Appeal Decision

Appeal Ref: APP/R5510/W/21/3286382

34 Acacia Avenue, Ruislip, HA4 8RG

- The appeal is made under section 78 of the Town and Country Planning Act 1990 against a refusal to grant planning permission.
 - The appeal is made by Panoramic Developments Ltd against the decision of London Borough of Hillingdon Council.
 - The application Ref 1788/APP/2021/3141, dated 12 August 2021, was refused by notice dated 25 October 2021.
 - The development proposed is 1no. detached 4-bed dwelling house and 2no semi-detached 4-bed dwelling houses.
-

Drawing Title
PLOT 1
FLOOR PLANS AND
ELEVATIONS

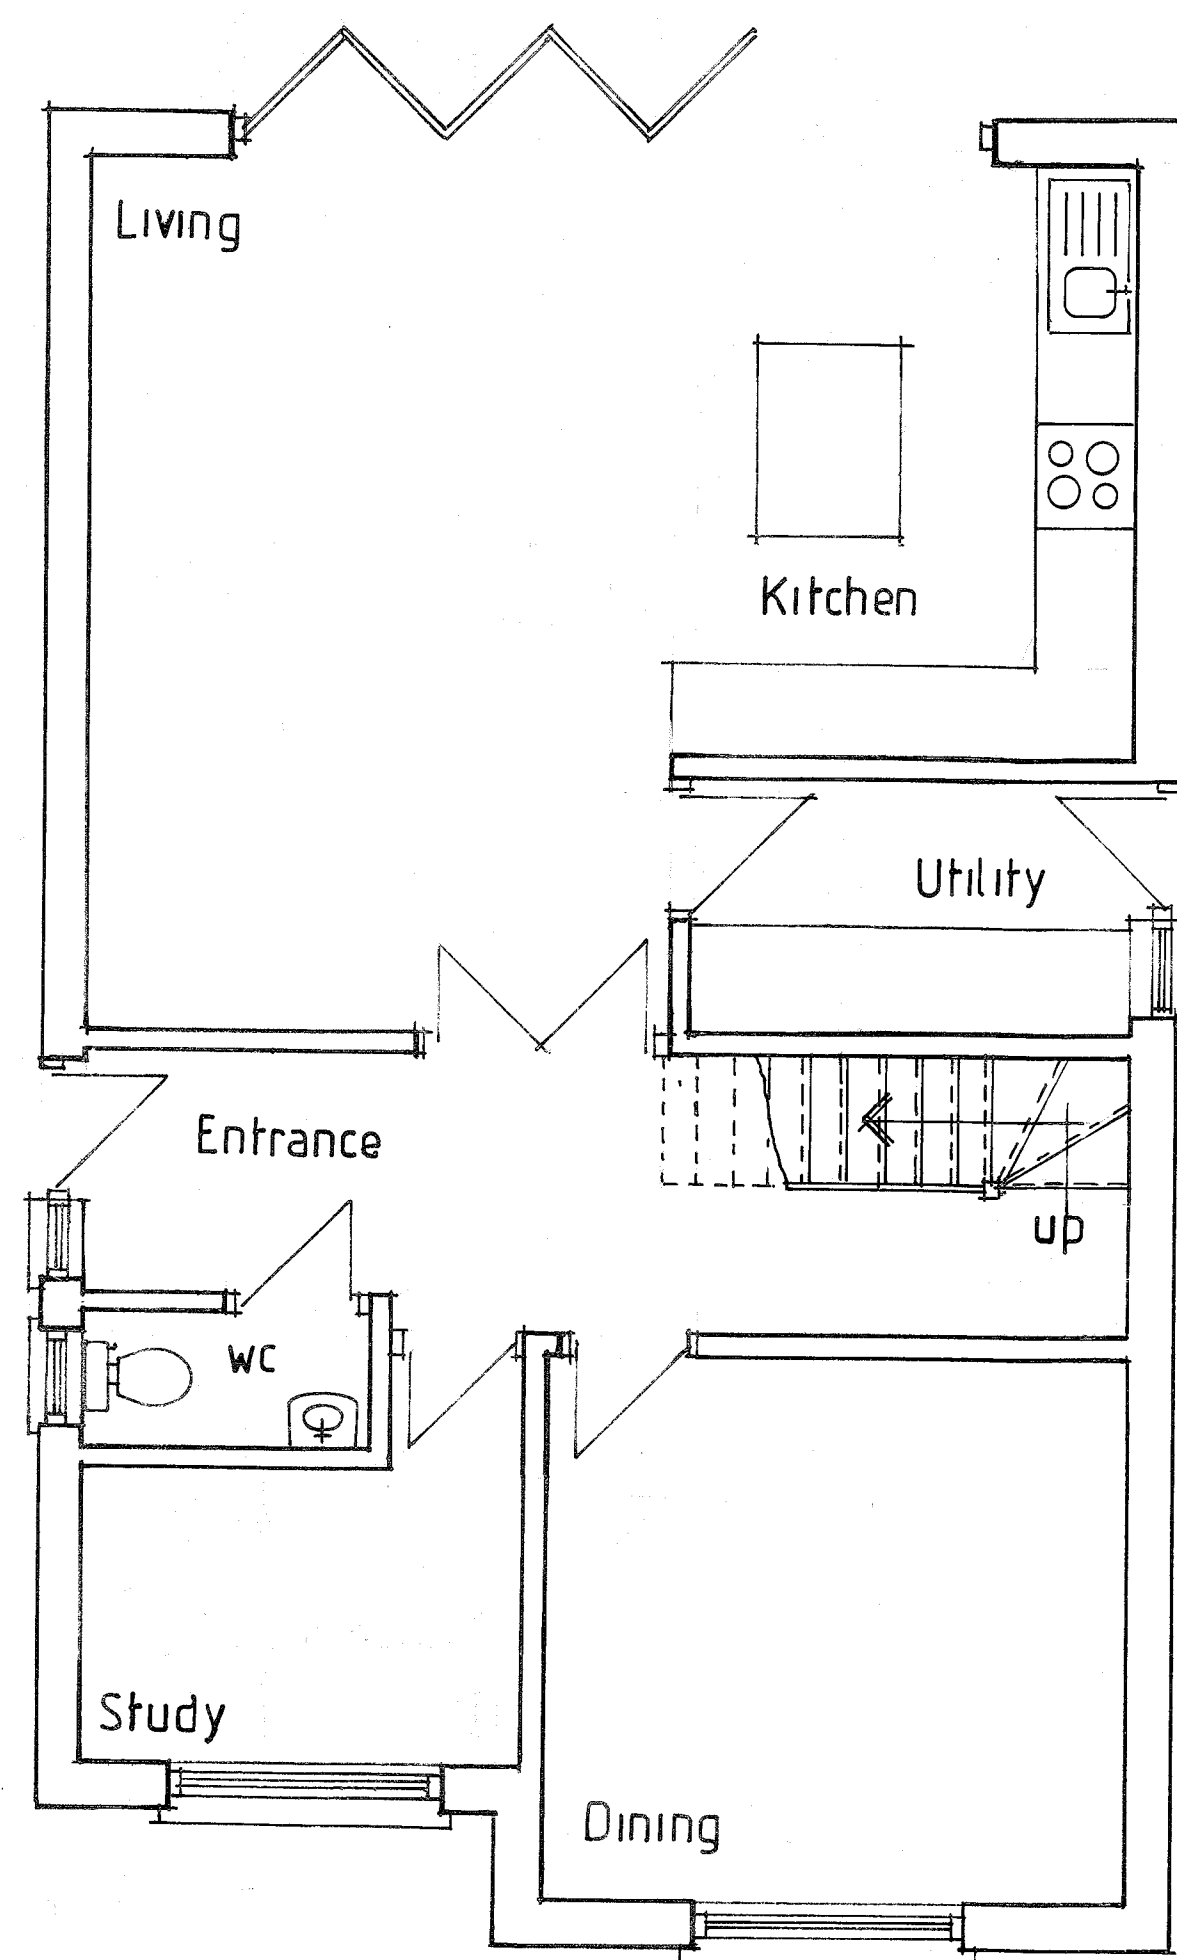
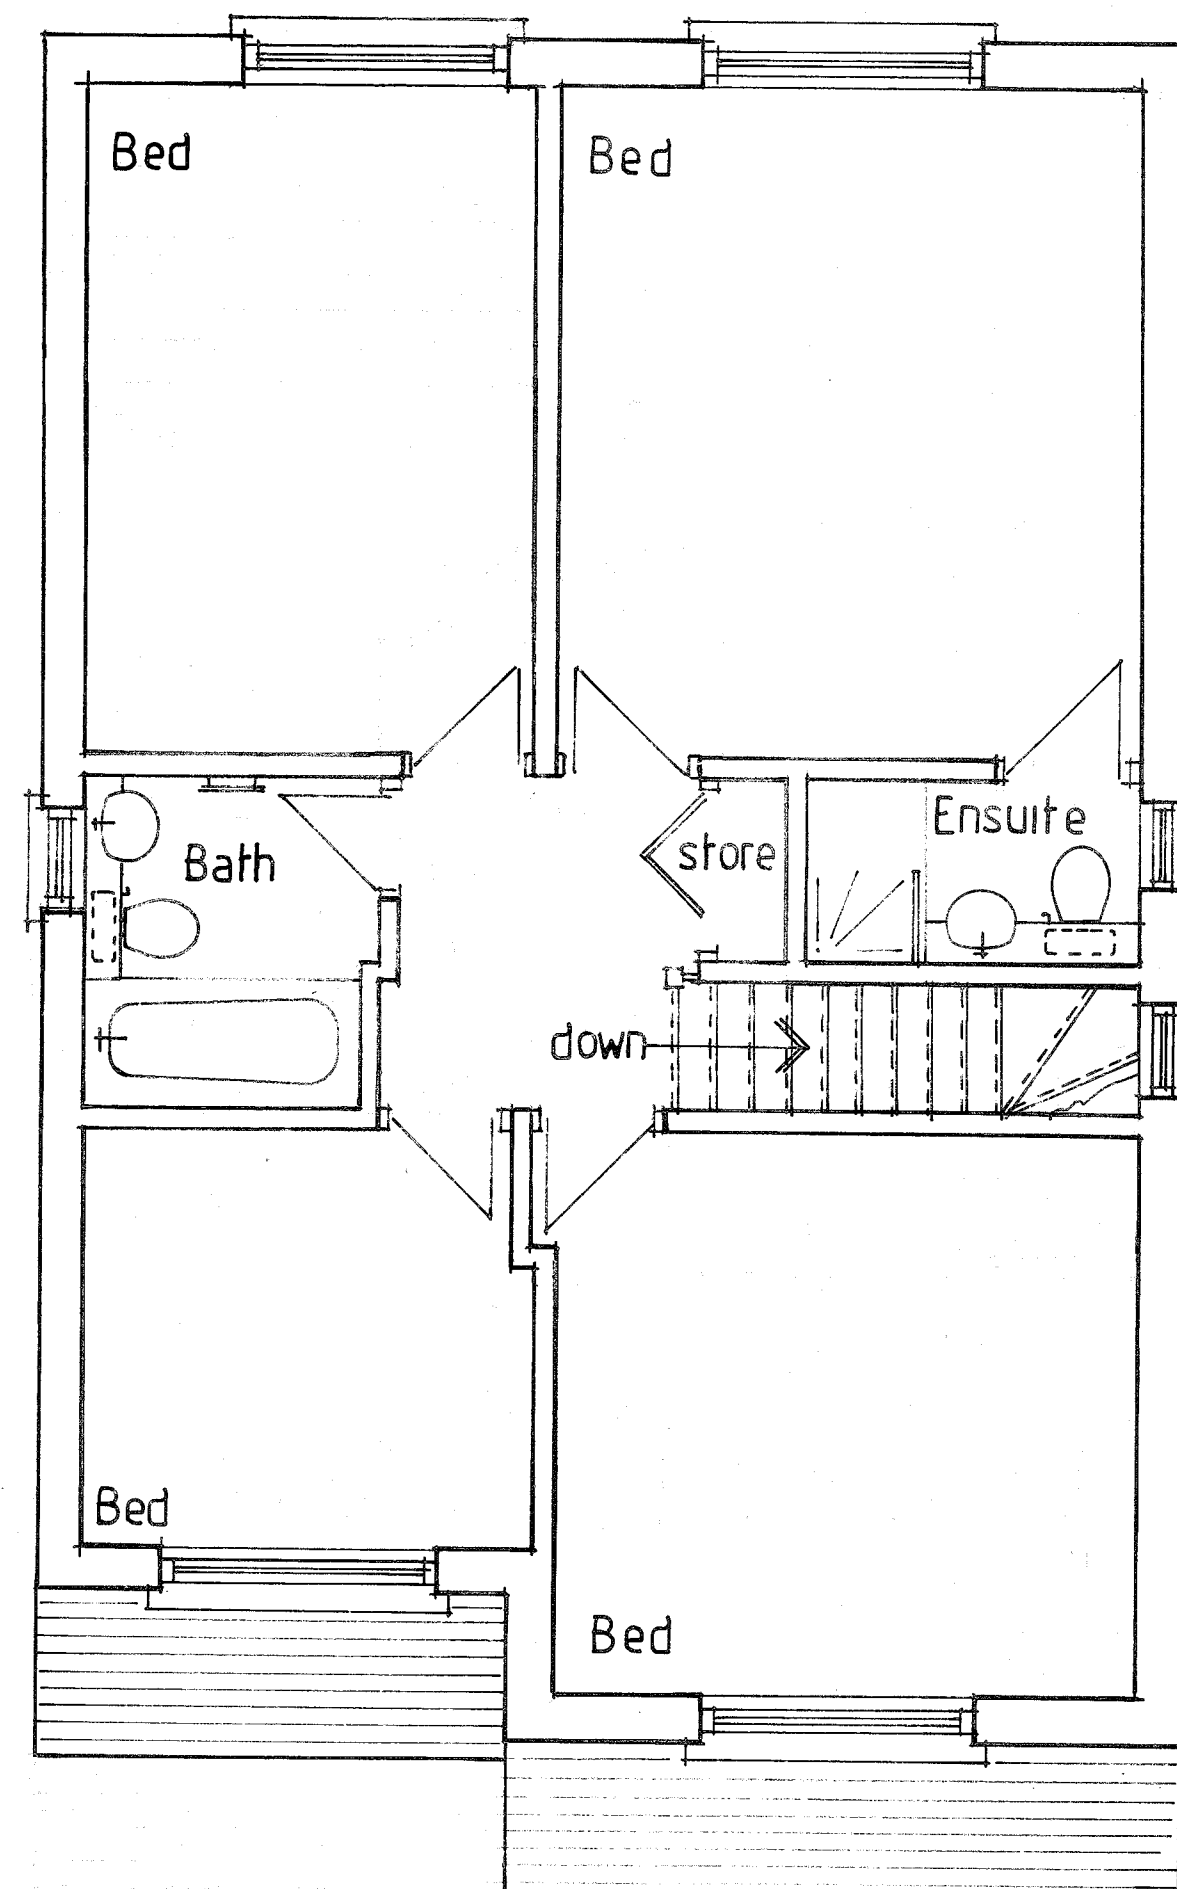
10. In addition, Plot 1 provides a study on the ground floor. I have taken into account the Council's stance on the potential use of this space as a bedroom. If taken as such, the size of which would fall below the minimum standards set down within the London Plan. This alone would not be determinative to lead me to find the proposal would fail on living conditions grounds. However, as a combination of factors, it adds to my overall consideration of the scheme on this main issue, and leads to my conclusion on the matter.

15. The London Plan 2021 reinforces the need for accessible housing within London, in particular Policy D7. As the ground floor would be otherwise fully accessible, the limited size of the W/C would be a significant obstacle to a less mobile person.
16. The proposal is for full planning permission whereby approval is sought for the layout, with the floor plans before me. The appellant may point to the proposal conforming to Building Regulations when the time comes. However, without the information before me, I am not convinced that the proposal would meet the required accessible standards to provide access for everyone.
17. To conclude on this main issue, due to the lack of inclusive design, the development would therefore not comply with Policy D7 of the London Plan 2021 in its objectives to provide accessible housing.
